**Re: Lot 10 Block 3 Unit 22 SAD 228
8001 Camino Alderete
Volcano Cliffs Subdivision
Grading & Drainage Plan
Engineer's Stamp dated: 3-8-21 (D10D003R10)
Pad Certification Dated: 3-11-2021**

Based upon the information provided in your submittal received 3/11/2021, this plan is approved for Building Permit.

GRADING AND DRAINAGE PLAN

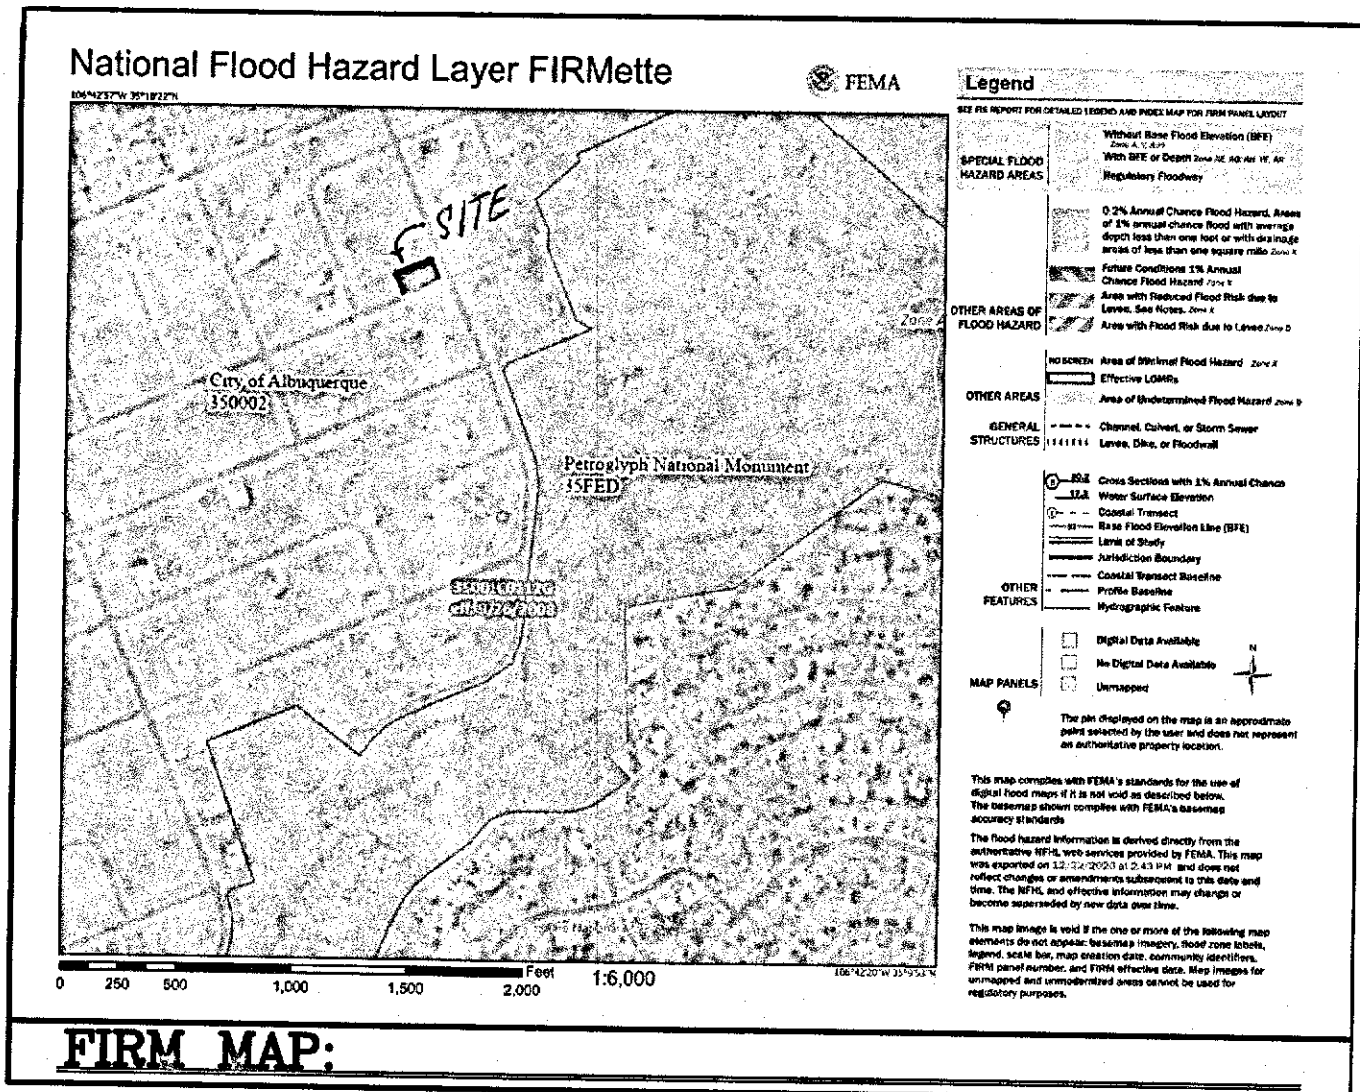
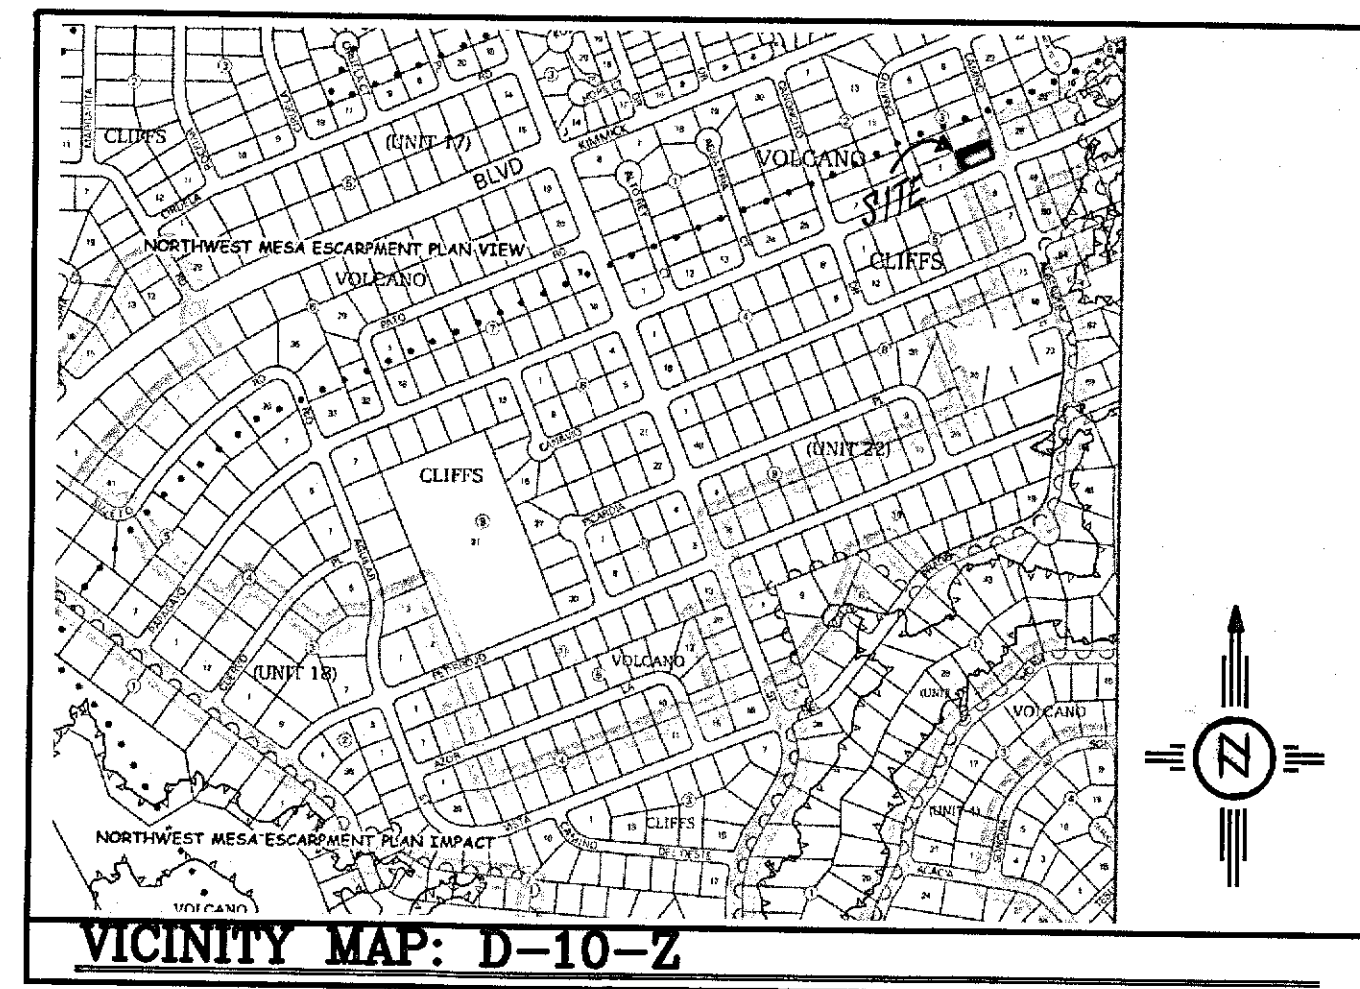
Advise the owner contractor not to use dirt as a ramp to climb the curb, use lumber or crusher fines for this purpose.

Reiterate to the Owner/Contractor that a separate permit for a garden/retaining wall must be obtained, with the approved G&D plan and Pad Certification. Also, let the owner/contractor know that if a pool is to be added in the future the G&D plan will need to be modified showing the location of the pool and the land treatment differences.
